Myra McKeown on behalf of the Mckeown Family (200048002).

IPR: BGSF ATP 337

Focus: [8.12] Comments made by RWE on a response made to EXQ1  
Section 3. 1.1 REP2-053 and REP-051/052 in Table 2.1

Baseline Traffic

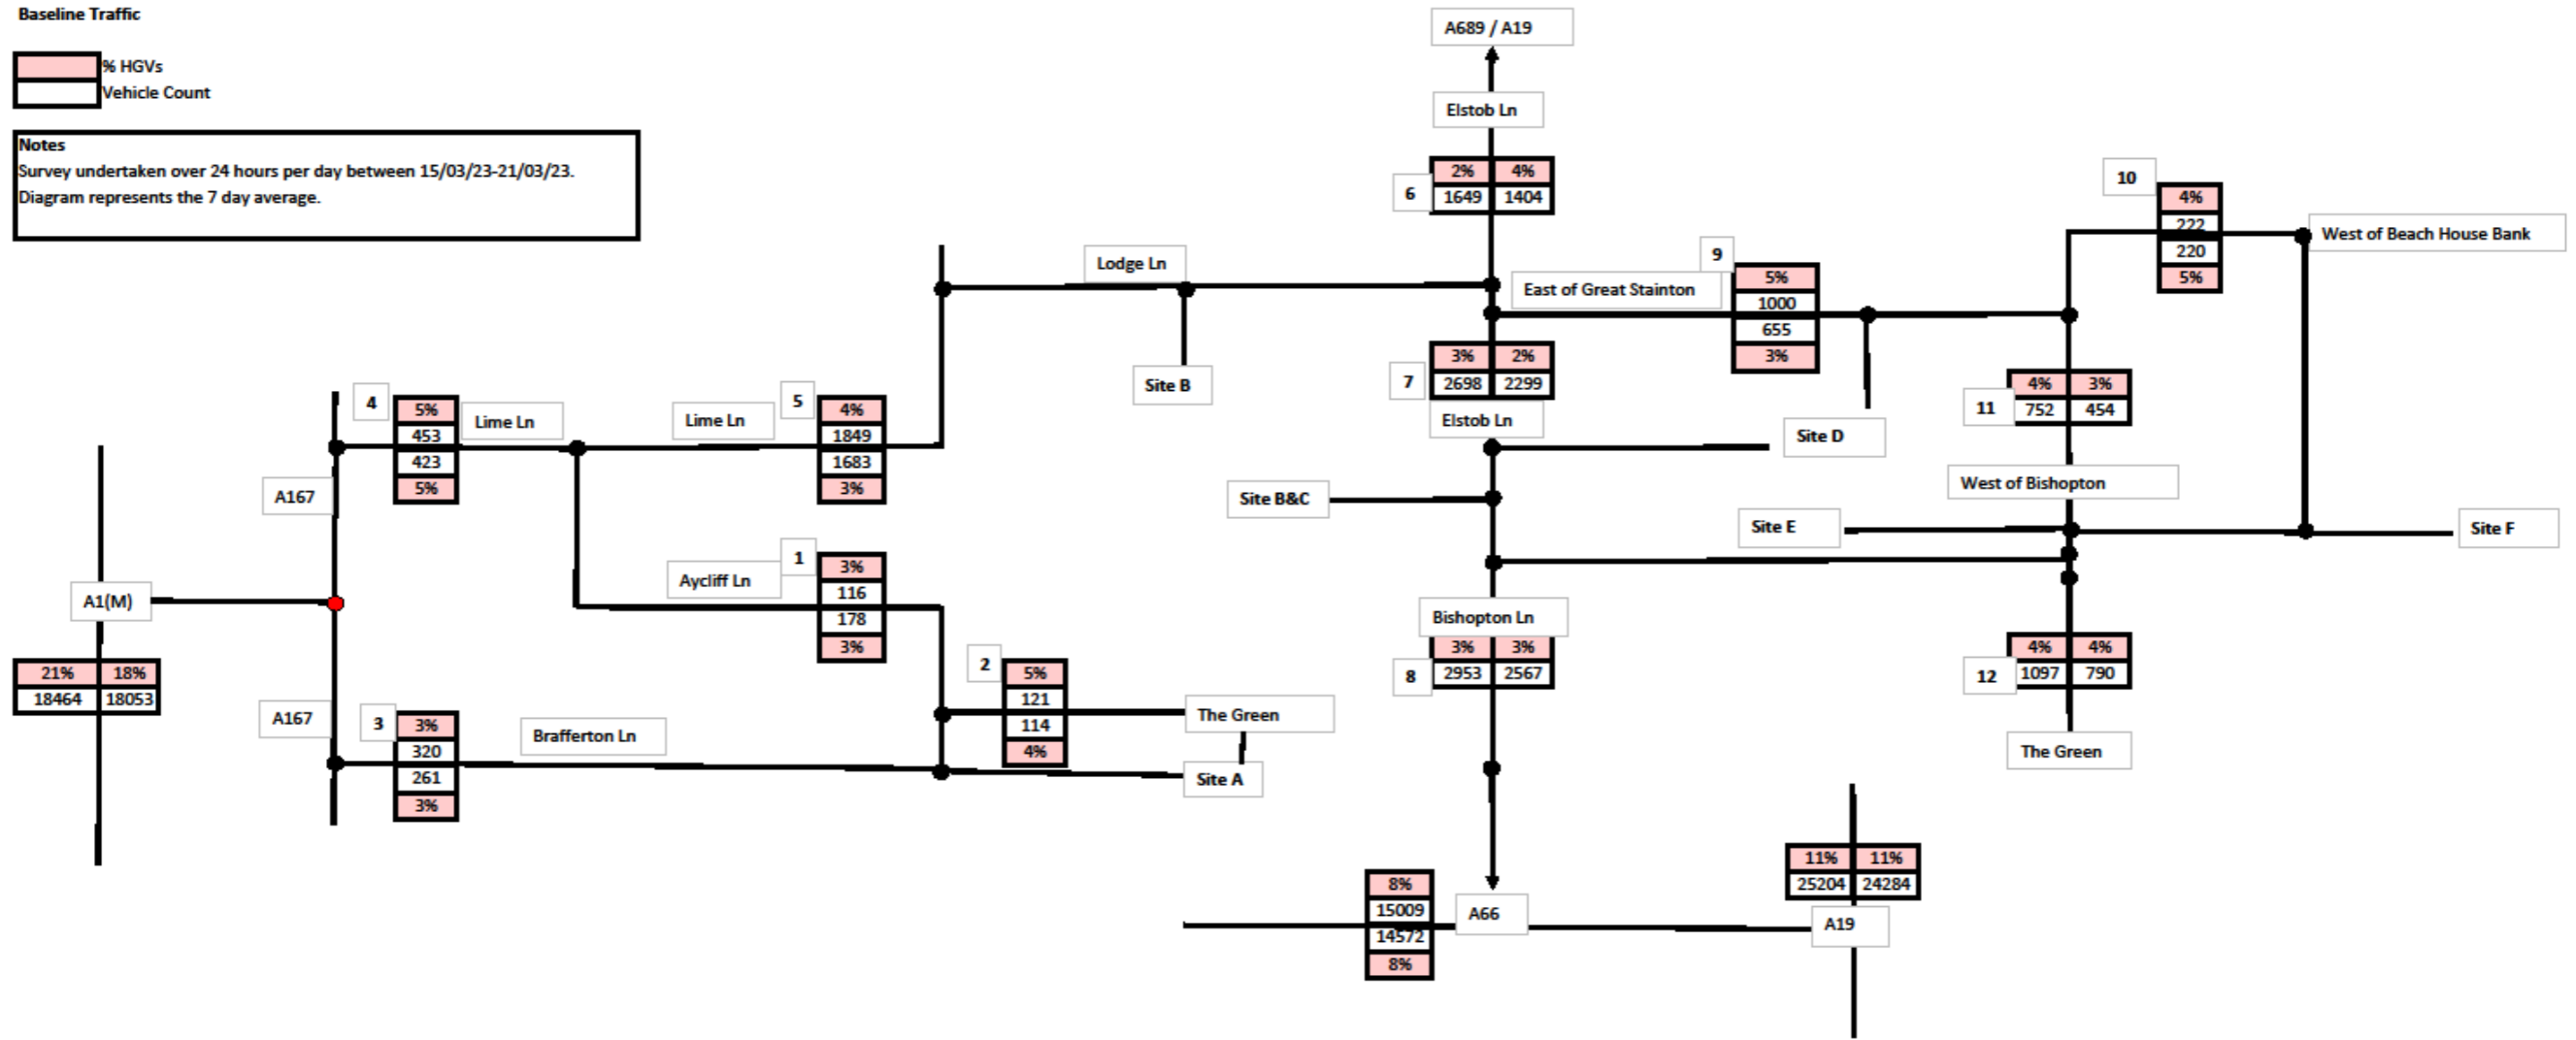
The resultant confusion and its effect on traffic assessment can be seen in the Mckeown family response [RR-515] to the Public Consultation held in Brafferton Data presented in grid form which relates to the traffic movements in this area has been similarly affected. See Pier Assessment Appendix 12.1 Survey Traffic Network Diagram Daily Traffic 01/05/2023. "High House Lane movement numbers- "121 vehicles daily".

We offer a simple solution. All reference to traffic movement should be presented as a 'combined assessment' ie that of 'the Green, Brafferton/High House Lane'.
